**RE: Juan Tabo Hills Estates Preliminary Plat, Project # 1005278**

The purpose of this letter is to explain how the comments as contained in the DRB Official Notice of Decision (May 21, 2015) have been addressed. The following items have been revised and are being re-submitted for review and approval.

1. Preliminary Plat (including Sheet 1 Vacation Exhibit),
2. Infrastructure List,
3. Sidewalk Exhibit
4. Perimeter Wall Detail
5. Grading and Drainage Plan

**PRELIMINARY PLAT FOR  
JUAN TABO HILLS ESTATES**  
WITHIN  
SECTION 33  
TOWNSHIP 10 NORTH, RANGE 4 EAST, NMPM  
CITY OF ALBUQUERQUE  
BERNALILLO COUNTY, NEW MEXICO  
JANUARY, 2016

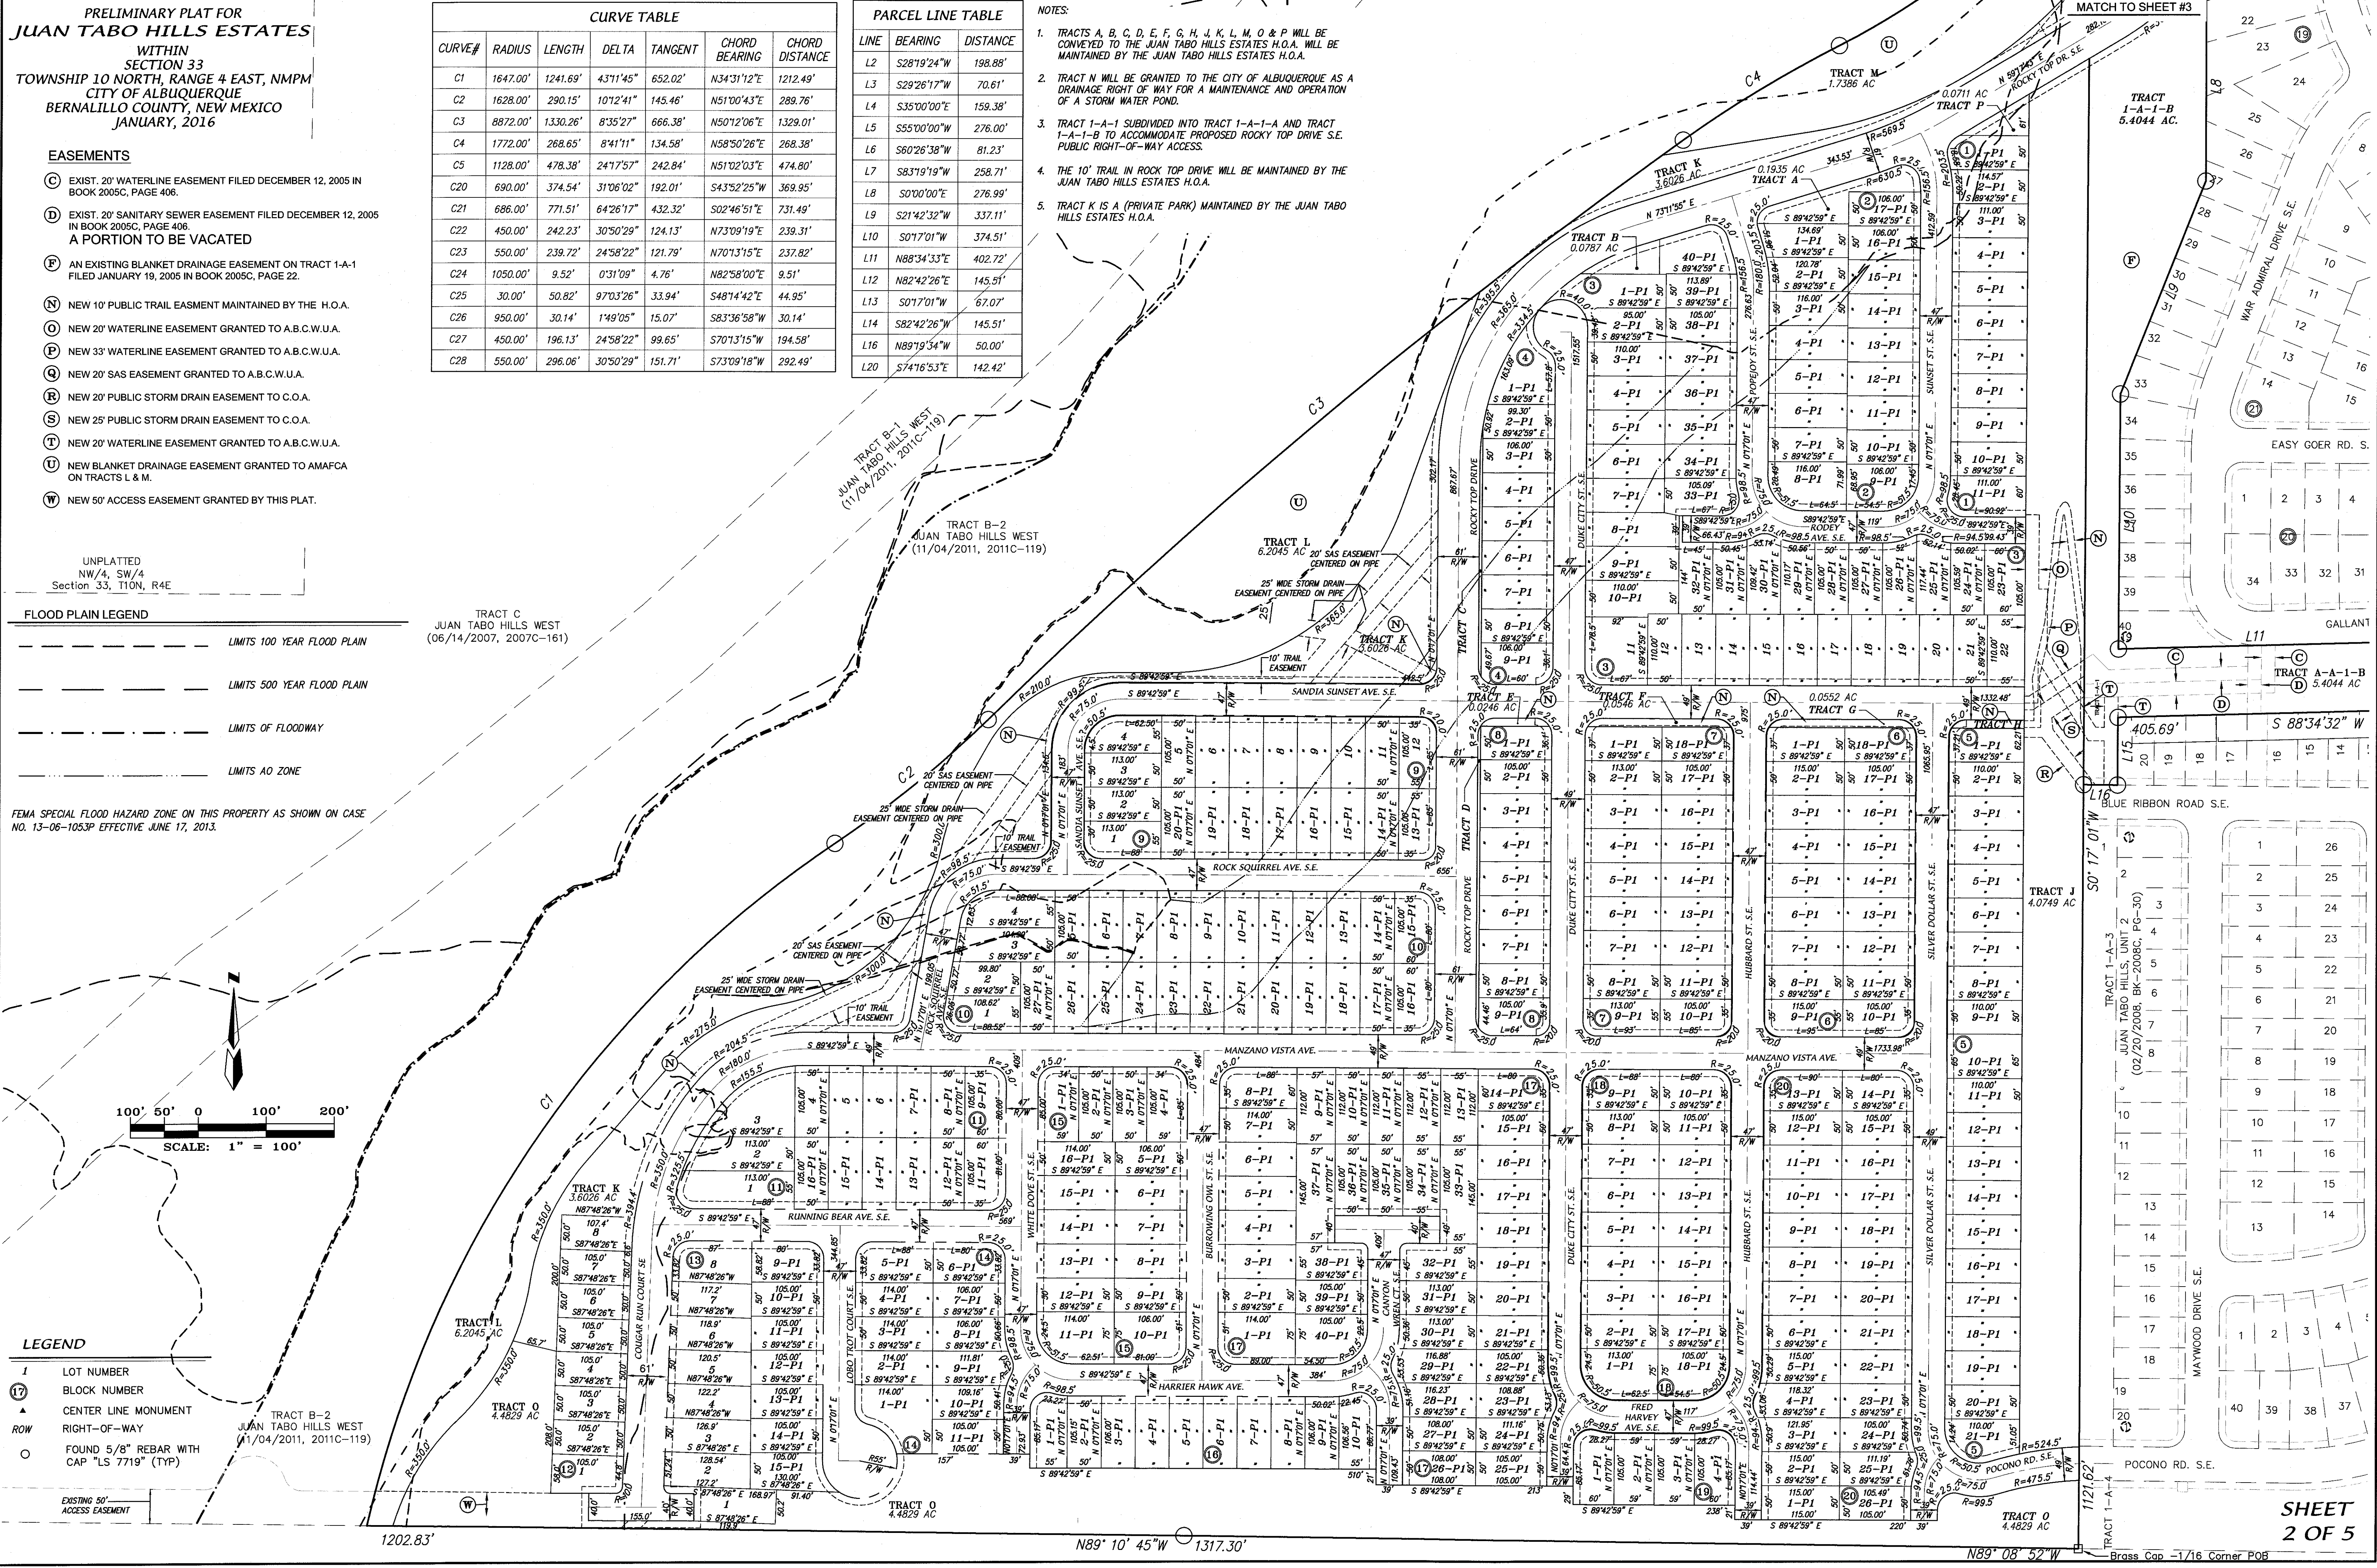
Planning Department comments (1) the original open space calculations table has not changed. (2) The Memorandum of Agreement signed by the owners, the SHPO and the Corps was handed to the DRB members at the first DRB. Copies of the 404 permit application have been submitted to Hydrology and AMAFCA. In a meeting with Mark Goodwin, the City Engineer determined that a CLOMR is not required. A LOMR is on the infrastructure list. The Grading and Drainage Plan has been modified per separate comments received from hydrology including the addition of cross-sections, spot elevations and slopes. The private grading on the HOA tracts on the south and east sides of the site shows level areas for the purpose of private enjoyment by the HOA, they are not "Trails" and are not open to the public. (3) Easement 'E', a 50' access easement being vacated with this plat, is now labeled on Sheet 1. Justification for the Vacation of this easement is as follows. This easement was created at the time Tract A was created for the purpose of providing access to Tracts B & C of the Juan Tabo Hills West Plat. That access is being replaced and improved by public roads onsite which lead to a new easement through Tract N being granted with this plat and by separate document on the adjoining Tract B as shown on sheet 2 of

the Plat. Grades in the new access location will be more easily traversed than are the grades of the existing terrain in the existing easement location. Justifications for the vacations of the other easements were provided in the explanation letter that accompanied the original application. The justification for the newly added vacation of a portion of the 20' SAS easement 'D' is that the existing line is in an inconvenient location for ABCWUA to maintain due to steep terrain and so it is being relocated to a new SAS line to be constructed through Tract J and in Sandia Sunset Ave. where it can more easily be maintained.
